**KIRKLEES METROPOLITAN COUNCIL
INVESTMENT & REGENERATION SERVICE**

Reference No: 2021/62/92998/E

Site Address: 1, Swincliffe Gardens, Birkenshaw, BD19 4BR

Description: Erection of single storey rear extension, increase in roof height and exterior alterations

ROOF PLAN

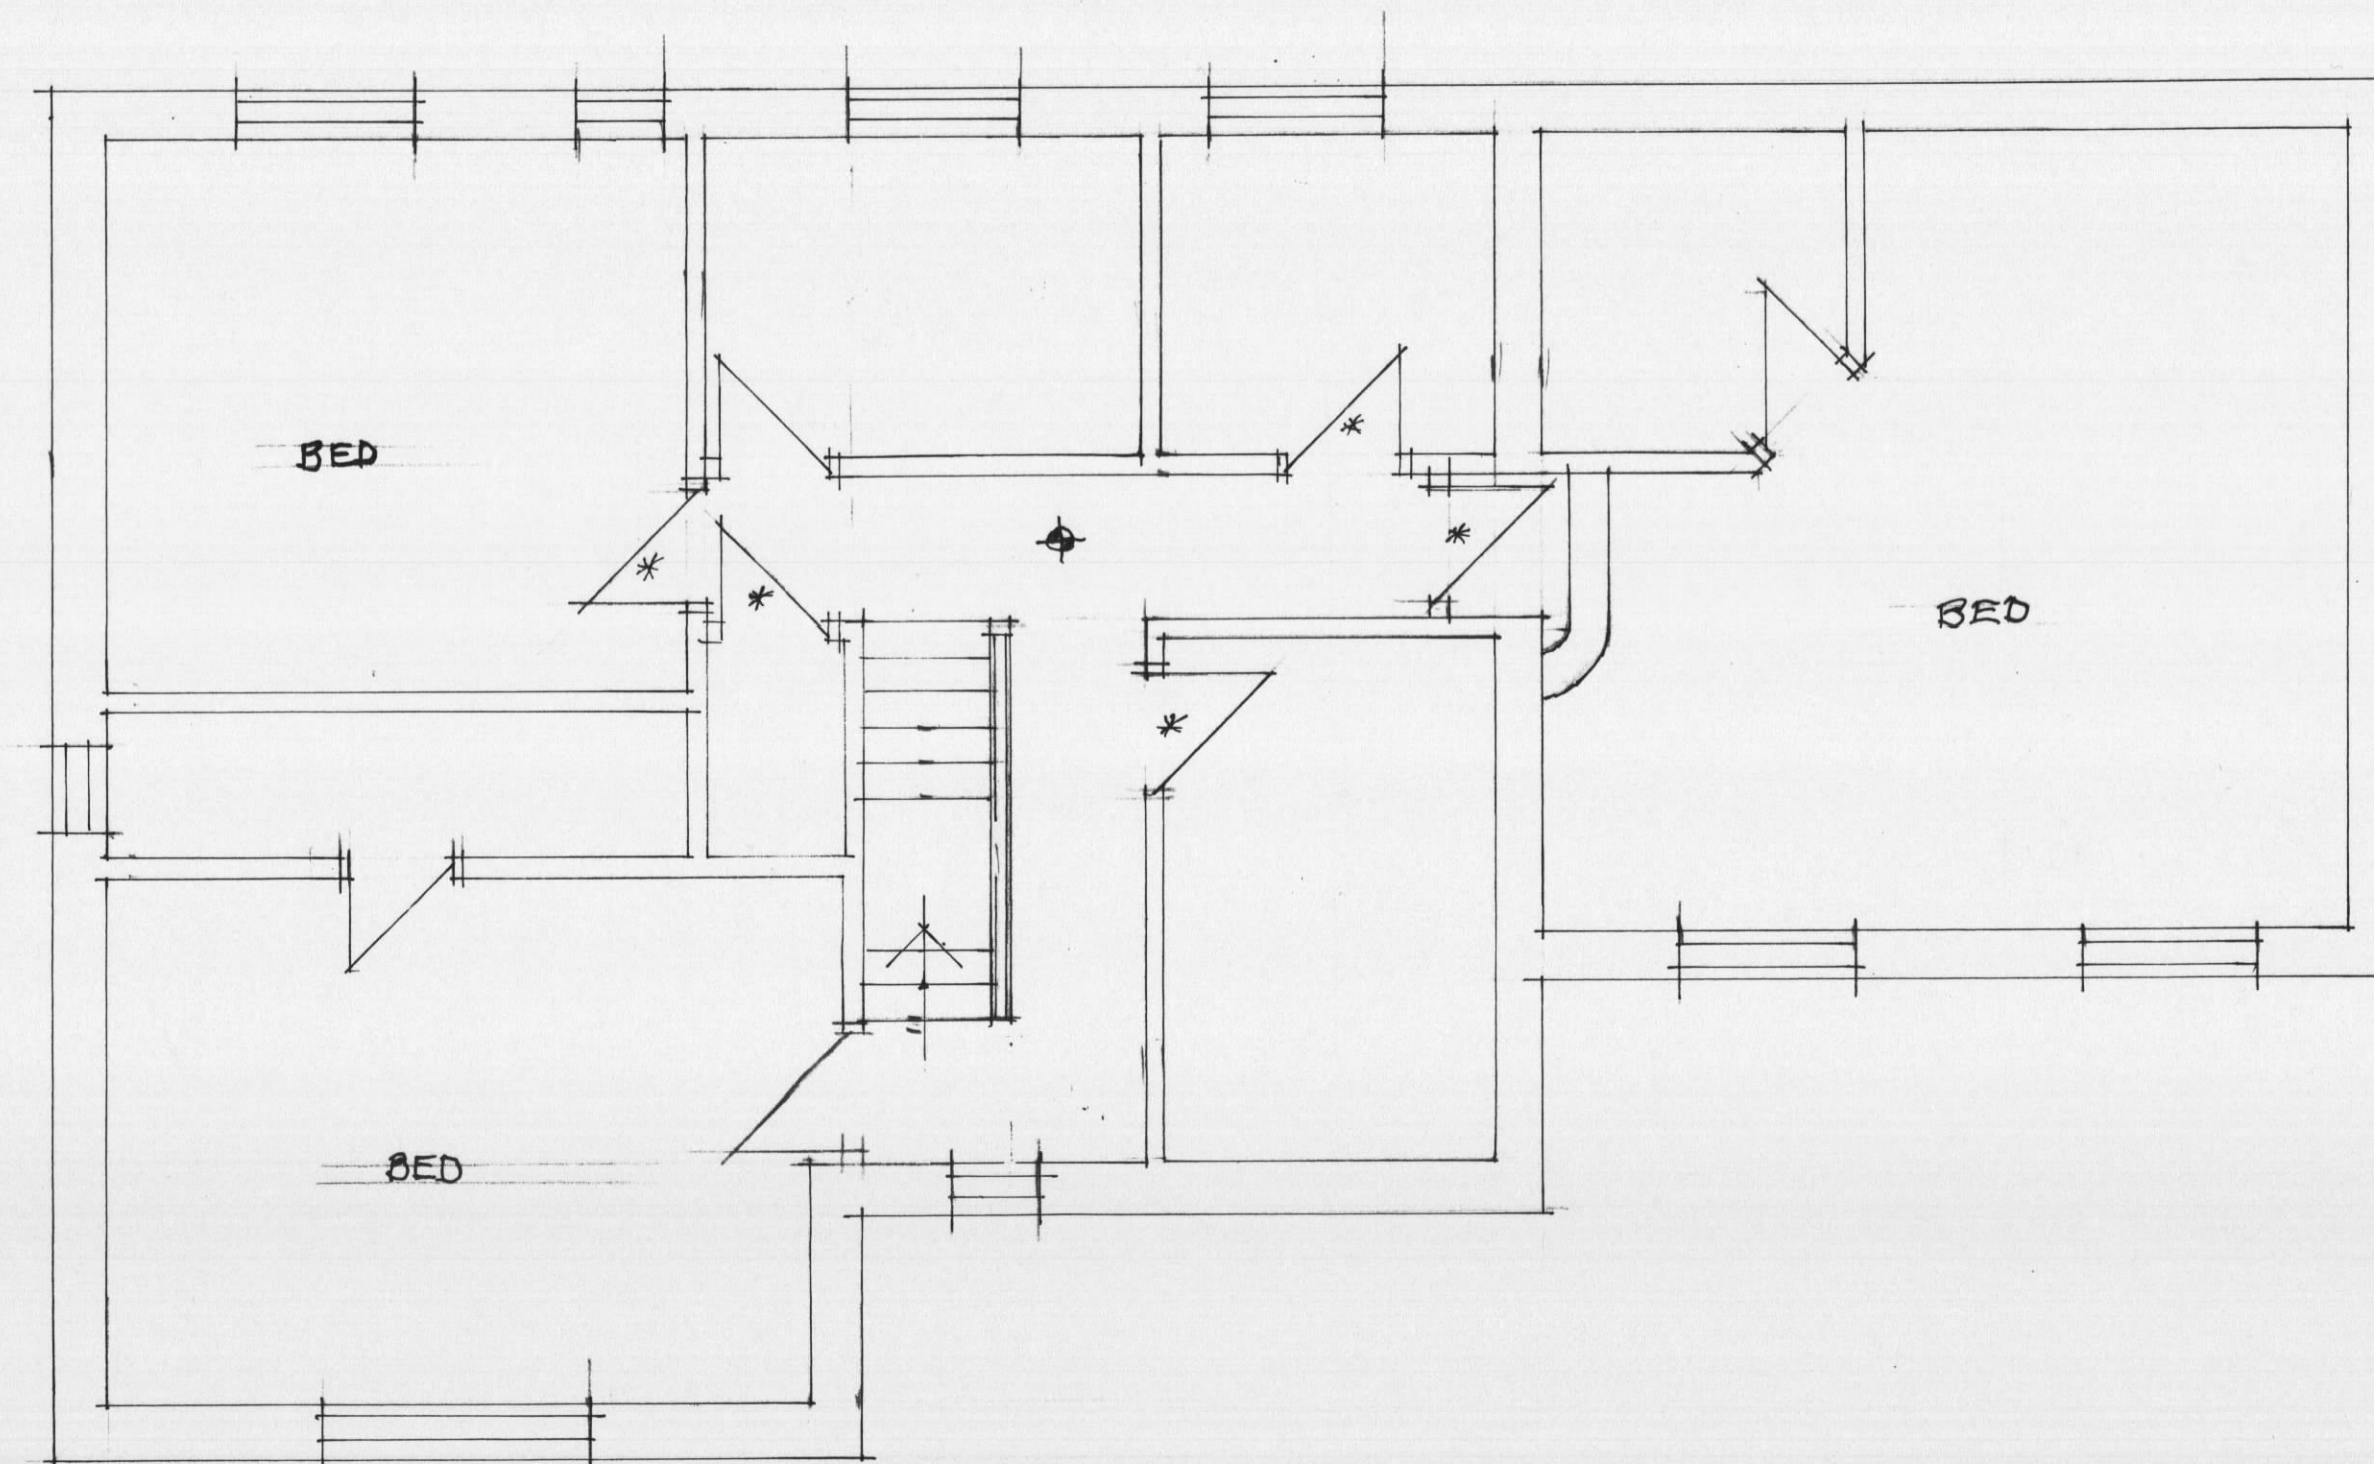
The proposed north facing gable en suite window would be conditioned to be obscure glazed.

Some 16m would be retained from the south east facing side elevation window, shown serving the bedroom to the nearest property, itself a side elevation. This is acceptable in regard to the SPD on house extensions.

3. The second floor (shown as 'roof plan') shall not be occupied until the second floor window at the north facing side elevation, shown serving the en suite, is glazed to a minimum of level 3 on the Pilkington scale of obscuration or

Drawing Title
ELEVATIONS

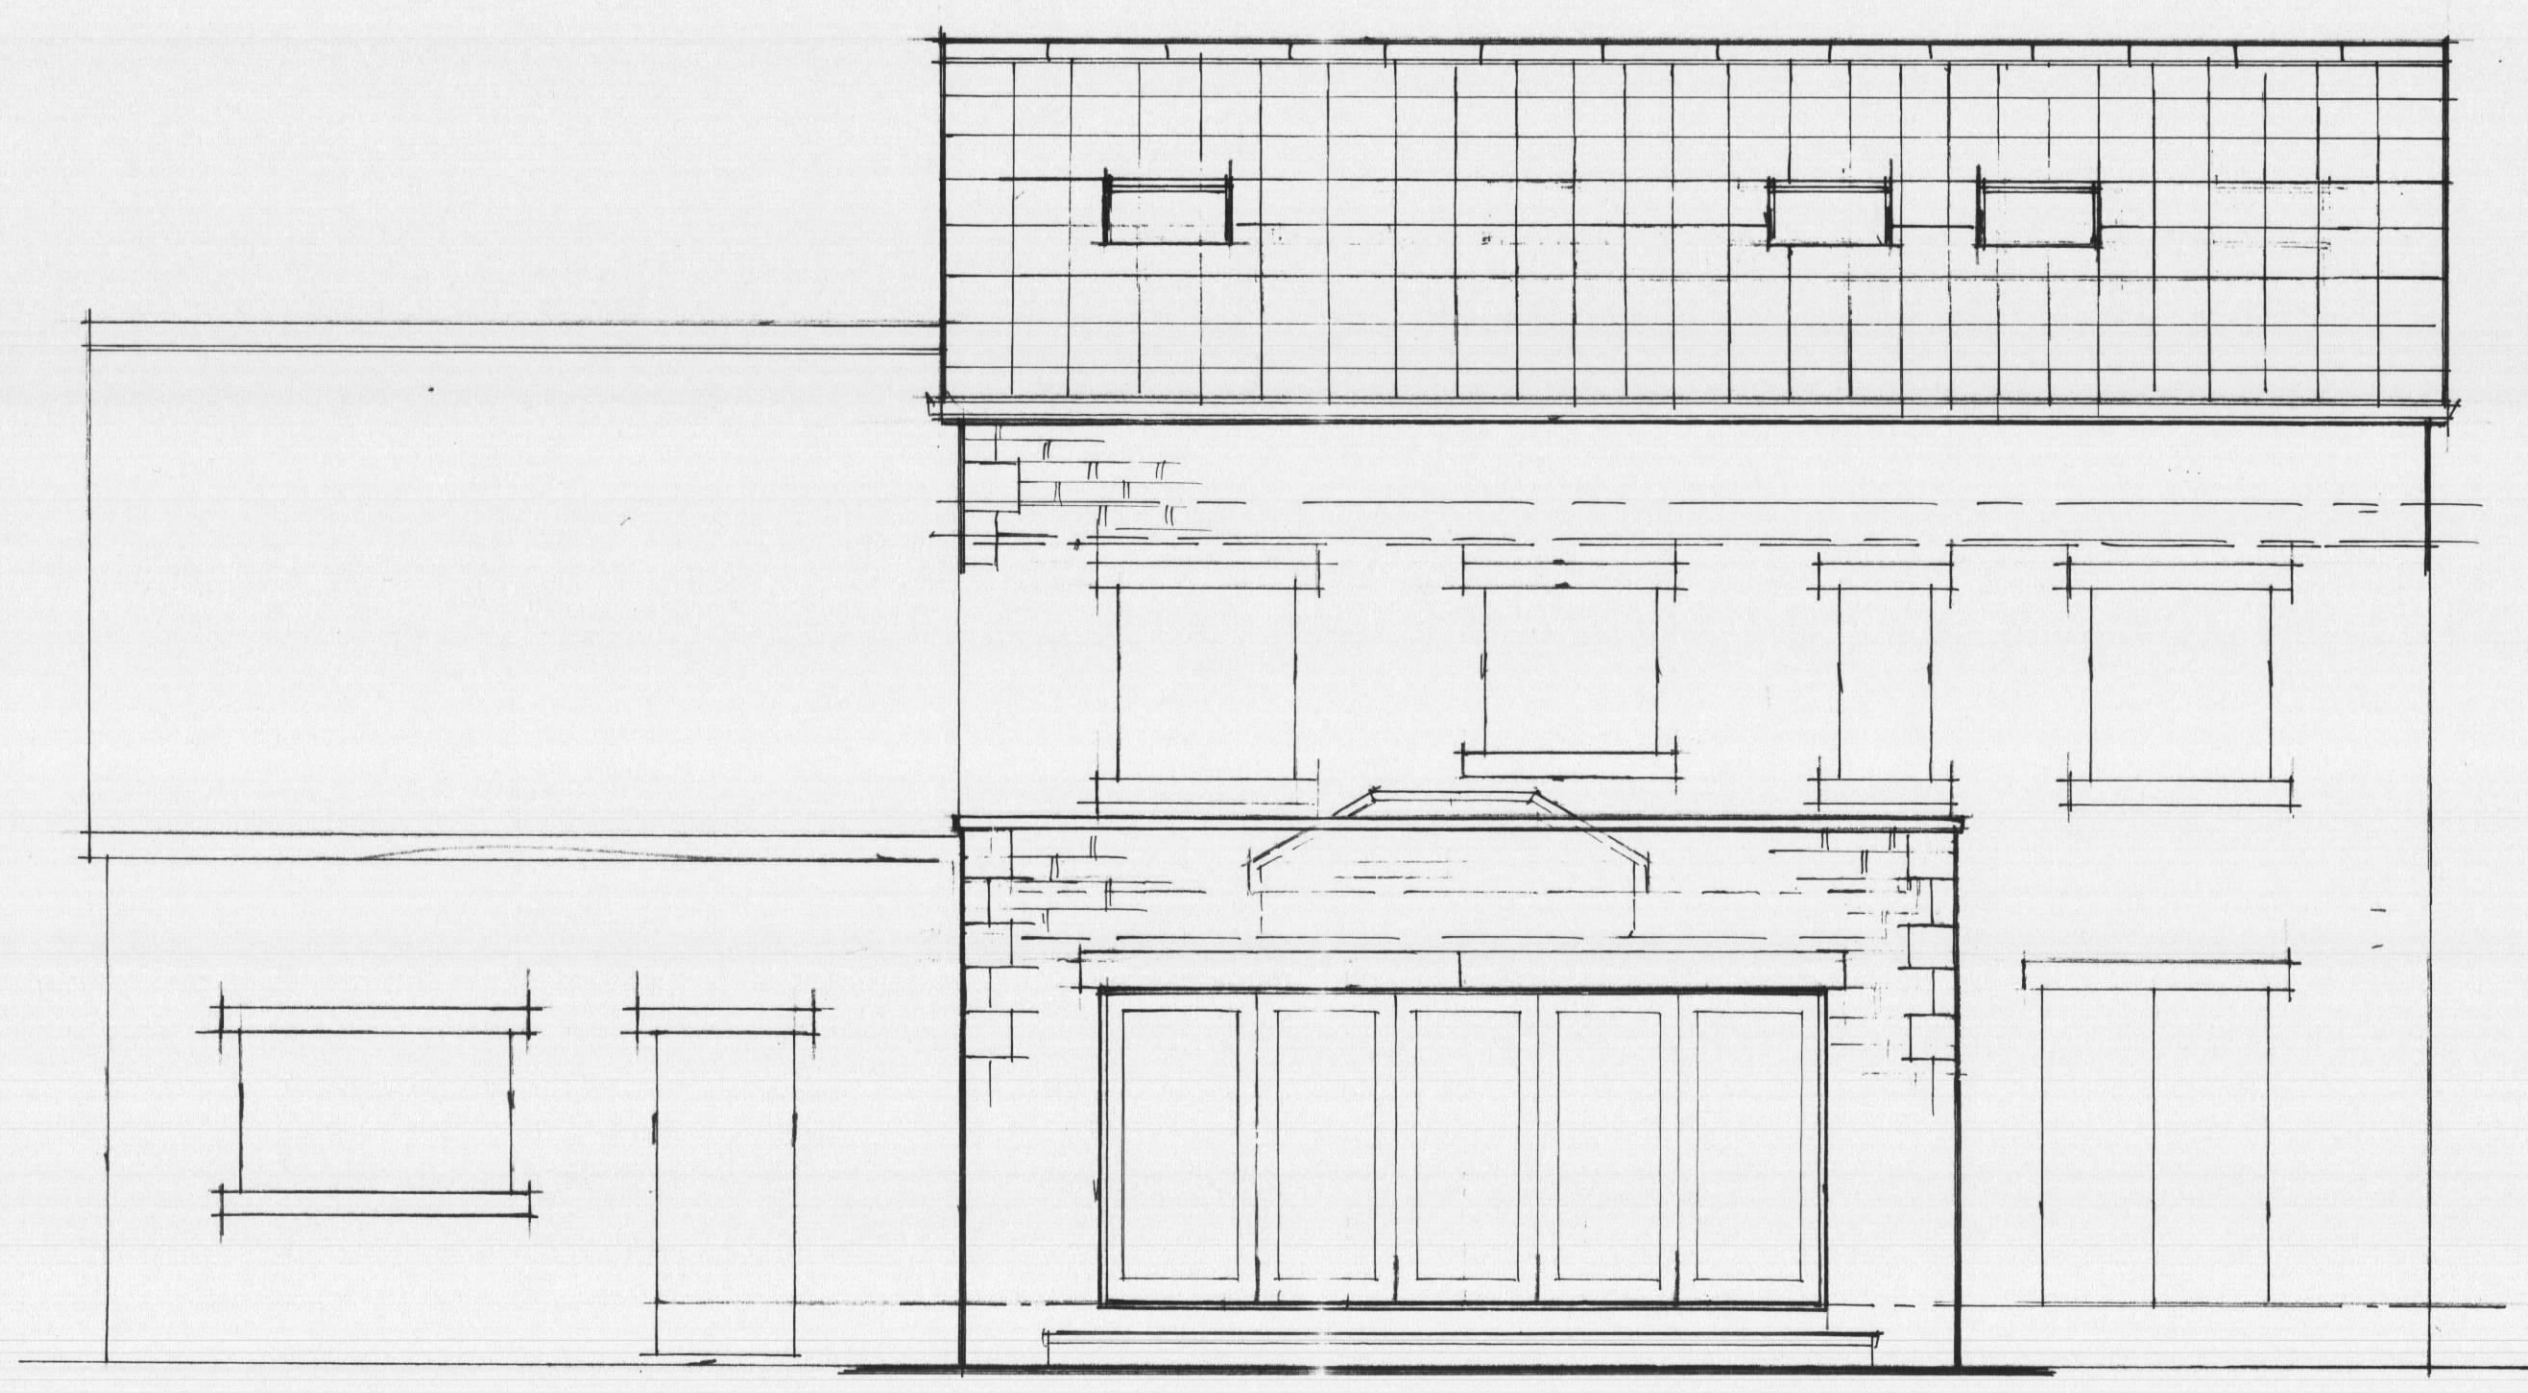
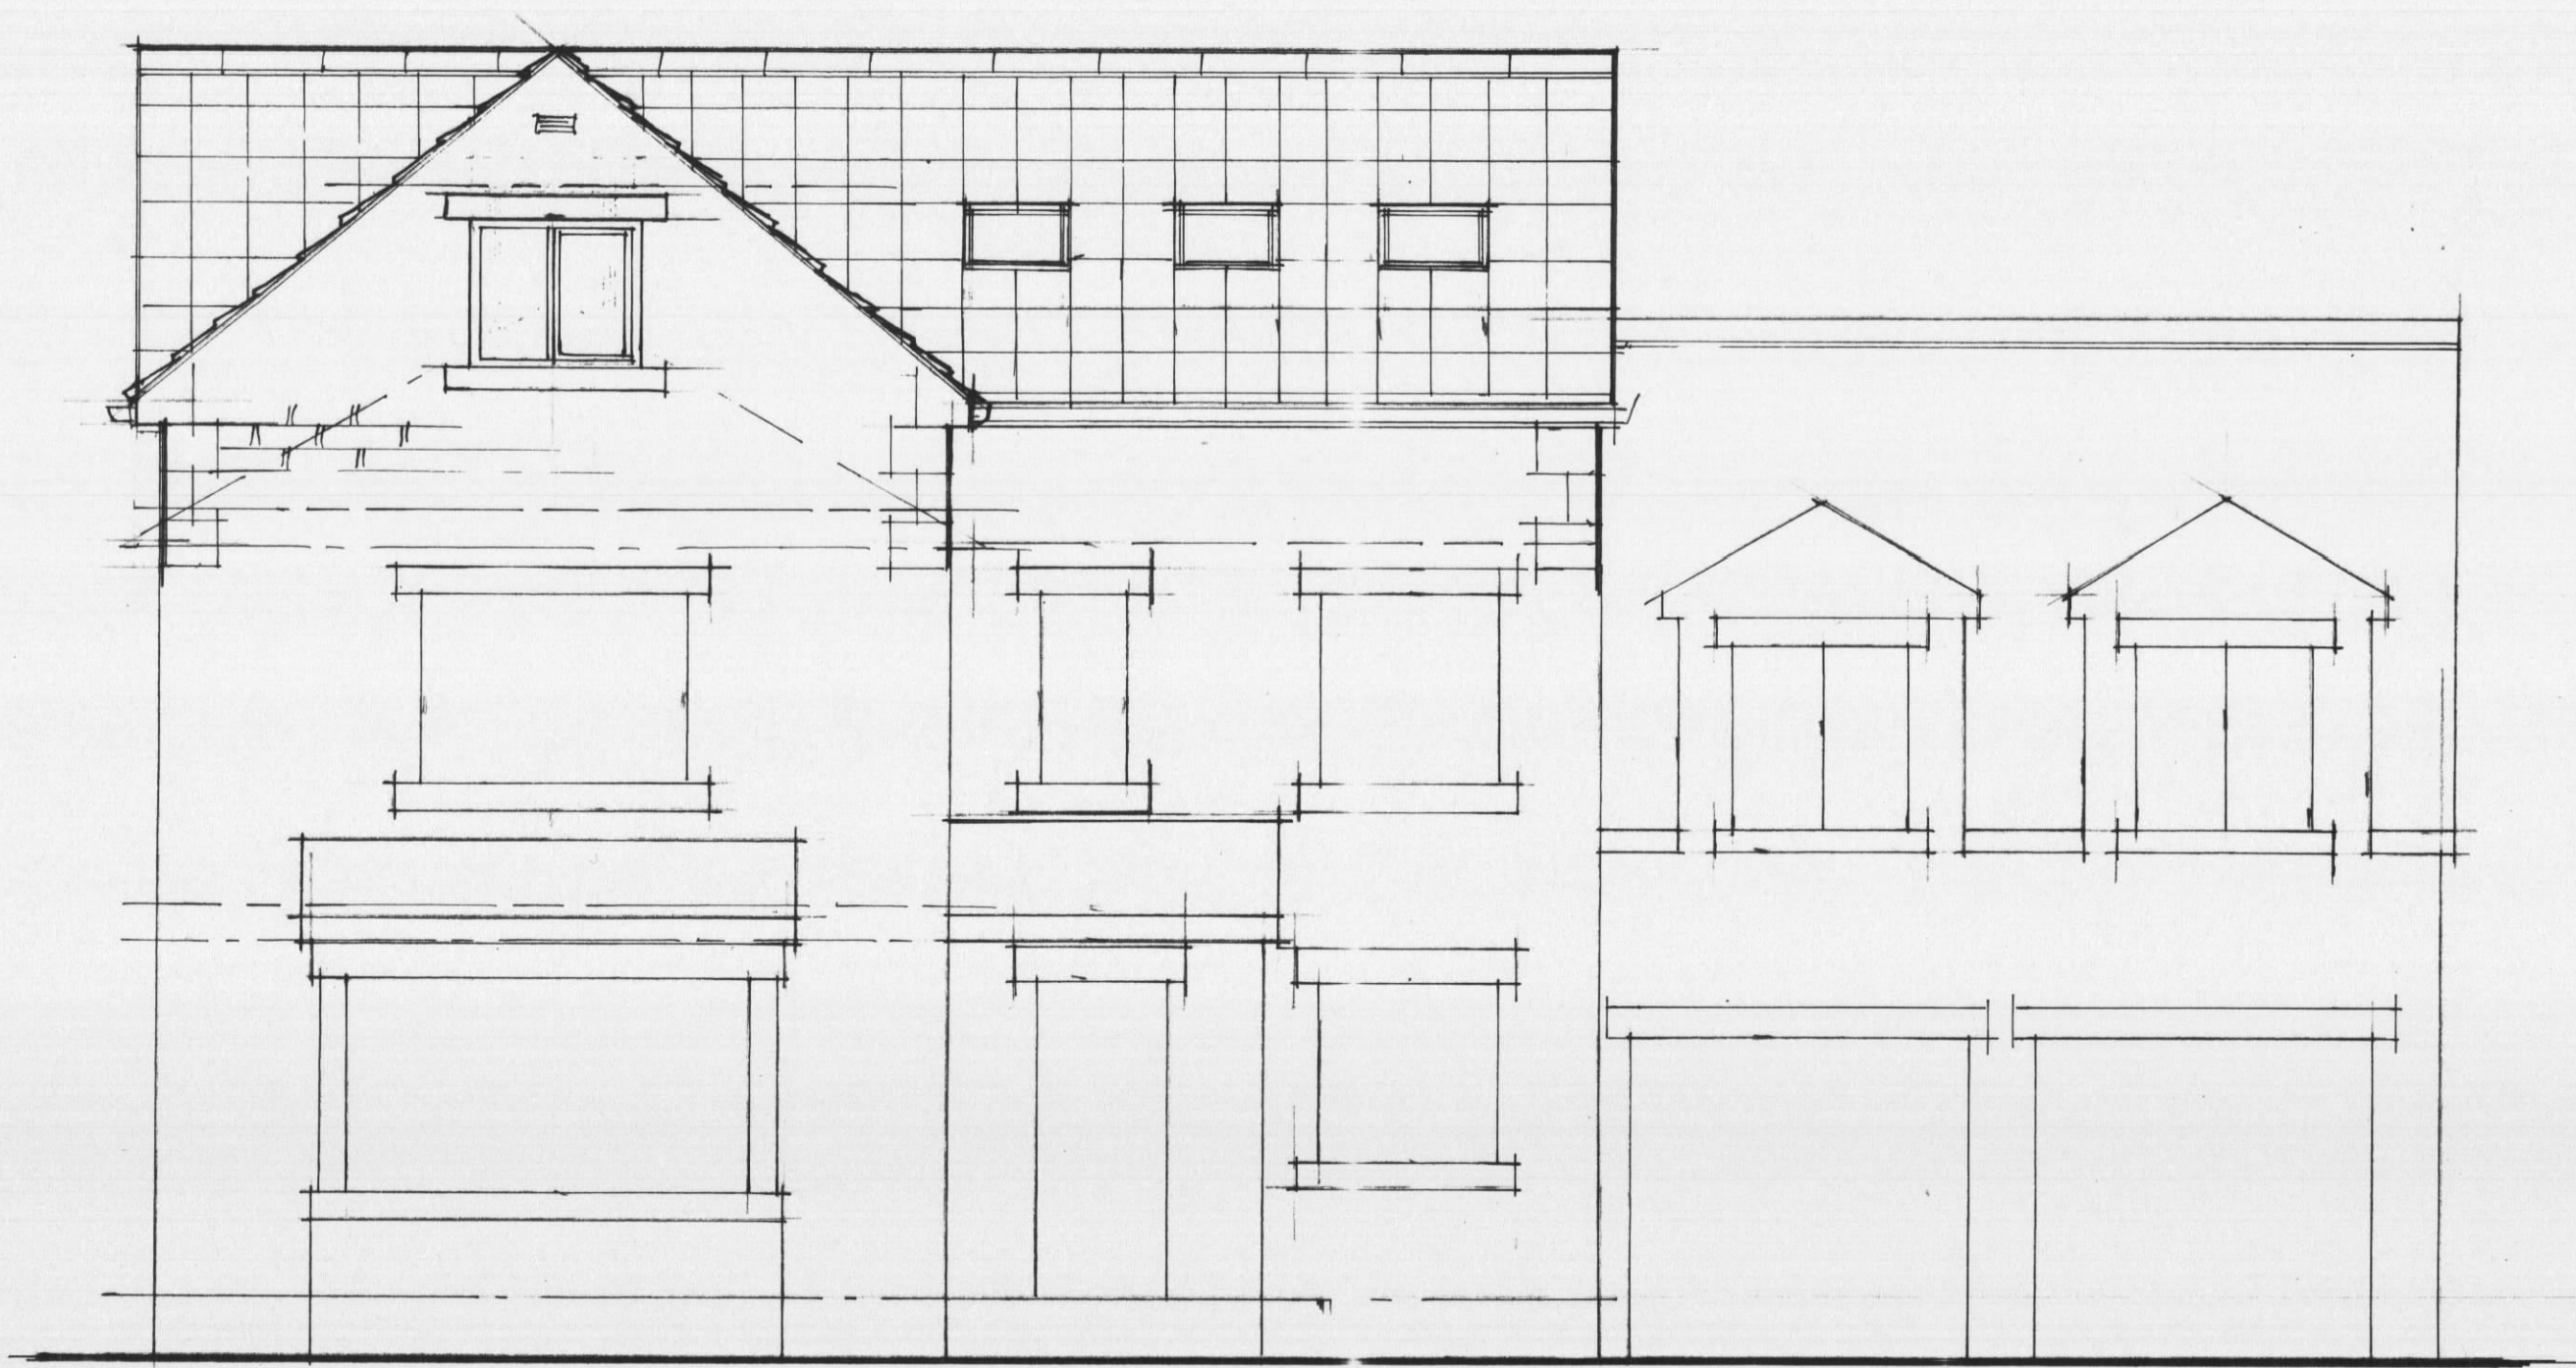
The house is sited at an angle in comparison with the housing development further west at Swincliffe Gardens and sufficient space would exist about the plot to visually absorb the increase in massing, such that the increase in height would

not appear incongruous. Similarly, the building line is broken by the angle of the front elevation and the roof ridge would not appear out of keeping in terms of the street scene when viewed from Bradford Road. The proposed rear extension would replace the conservatory element and would accord with the guidelines for such additions as set out in the SPD on house extensions.

The proposed palette of materials such as stone facing materials would clearly assimilate the proposed rear extension into the host dwelling.

The proposed increase in roof ridge height would not cause overshadowing to any neighbouring properties over and above that of the existing situation thanks to the space about the house in the plot. Likewise the single storey rear extension would not breach 45 degree lines of sight from any neighbouring habitable room windows.
